COMMUNITY DEVELOPMENT DEPARTMENT  
80 Columbia Avenue ♦ Marysville, WA 98270  
(360) 363-8100 ♦ (360) 651-5099 FAX

Re: Marysville Corporate Center – *Technical Review 1*  
PA 22004

RE: Marysville Corporate Center, File# PA22-004  
Binding Site Plan  
15908 47<sup>th</sup> Ave., Multiple Parcels

1 STORM PLAN - NW
 C1.35 SCALE: 1"= 30'

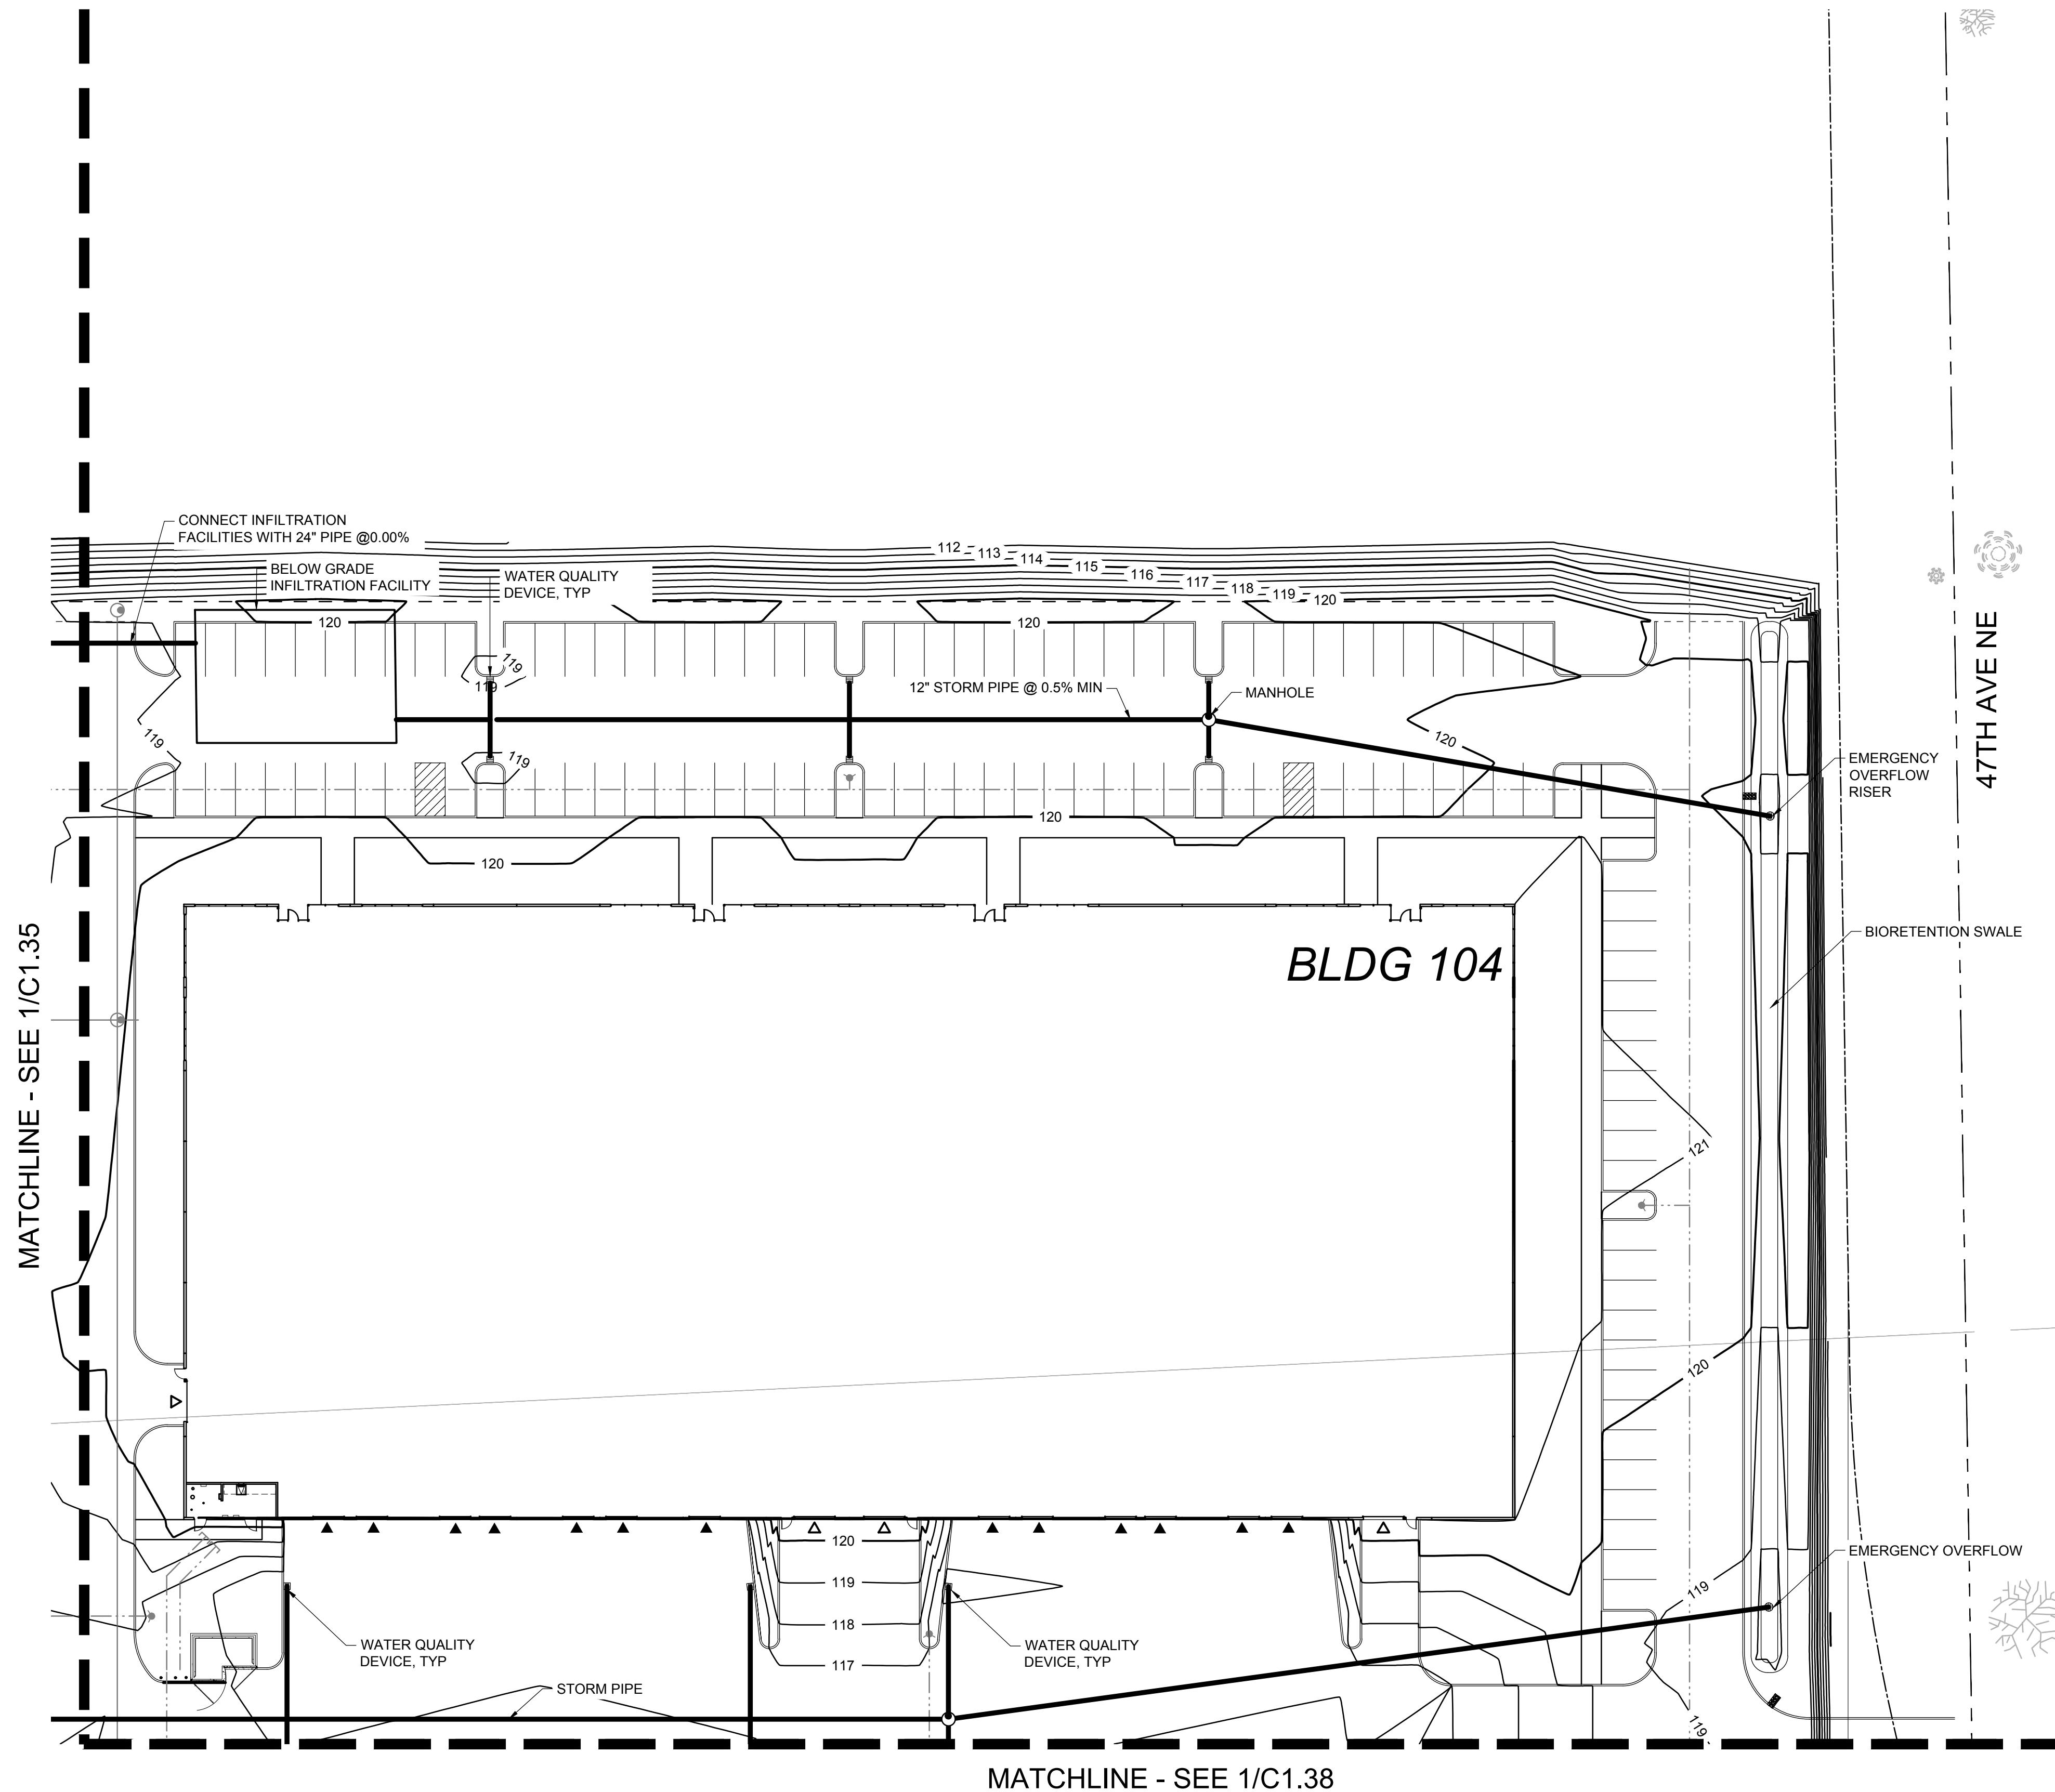
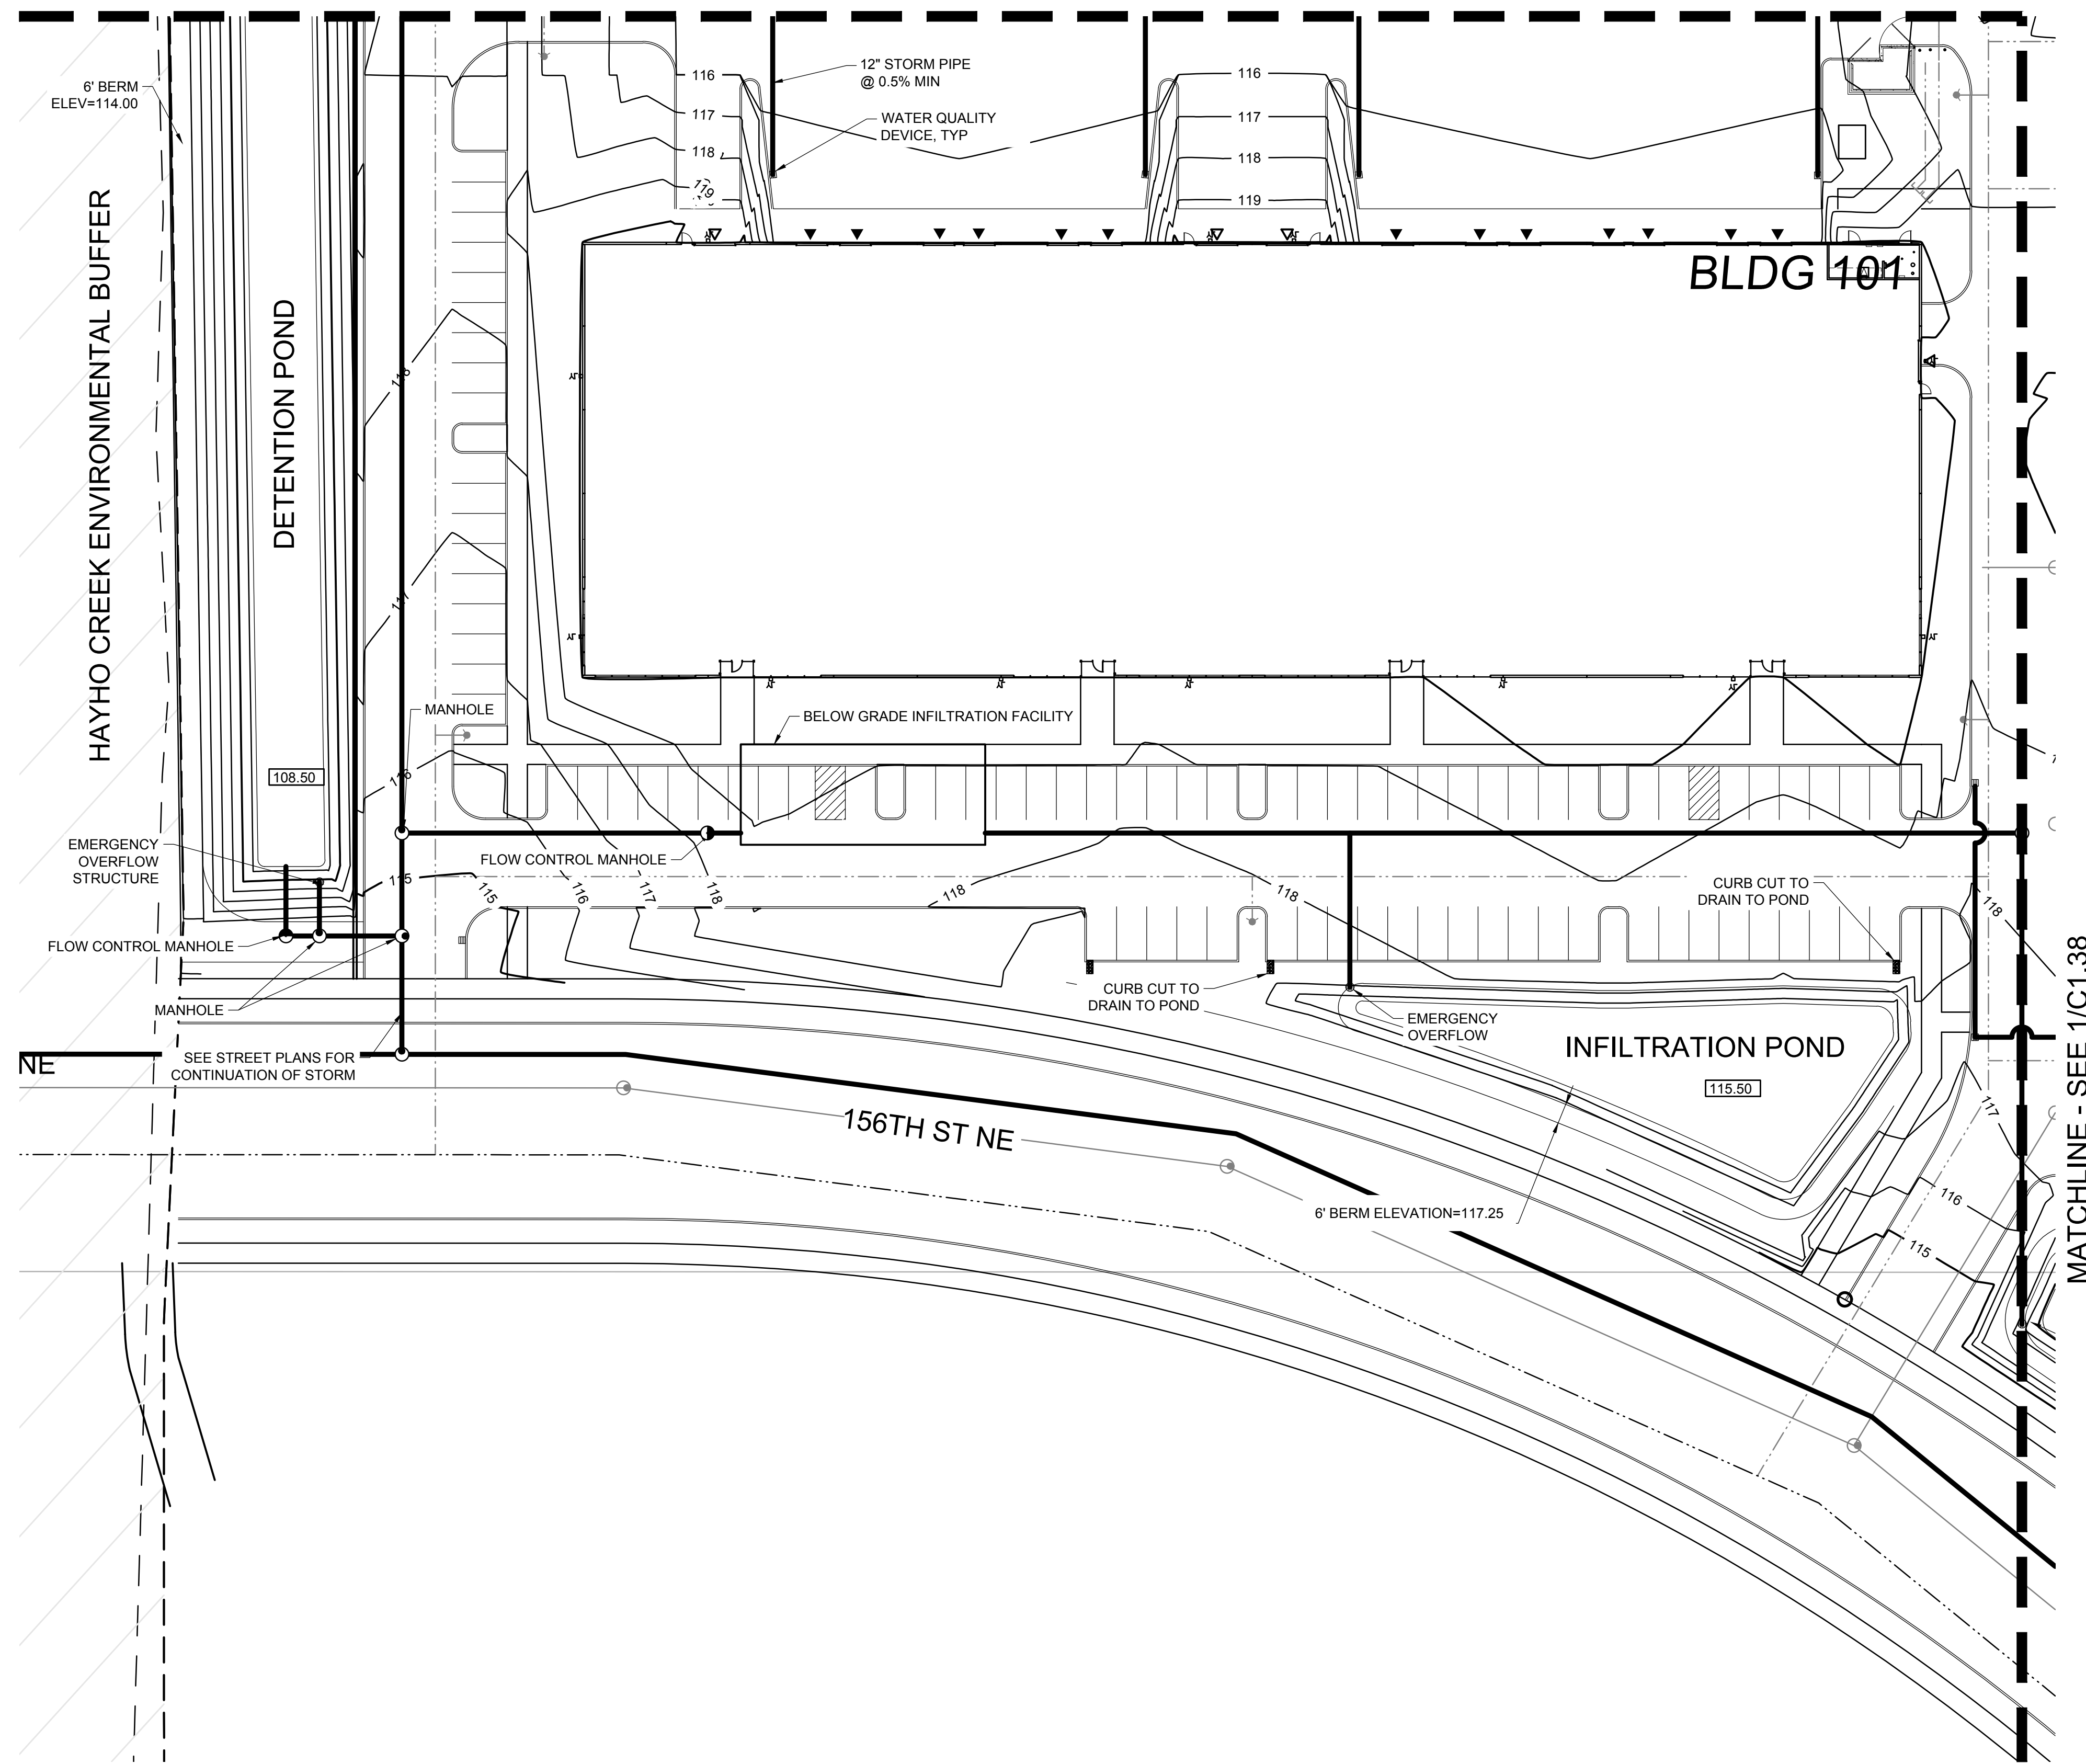
- a. Stormwater drainage: The city has adopted the 2012 Ecology Manual as amended in 2014. Projects above the 5,000 square feet threshold must comply with requirements stipulated in Volume I, Chapter 2 of the Stormwater Management Manual for Western Washington. The following revisions will need to be made to the drainage report in the next submittal:

- The report will need to be revised to account for the construction of 160<sup>th</sup> Street and 47<sup>th</sup> Ave and for extending 156<sup>th</sup> Street further to the east.

- Include a developed basin map that also shows where the runoff will be addressed for 160th Street and 47th Ave.
  - With what was submitted, we do not have verification that the infiltration facilities are meeting the required separation distances from the seasonal water table. Please also provide information that the bioswales are meeting the required separation distance.
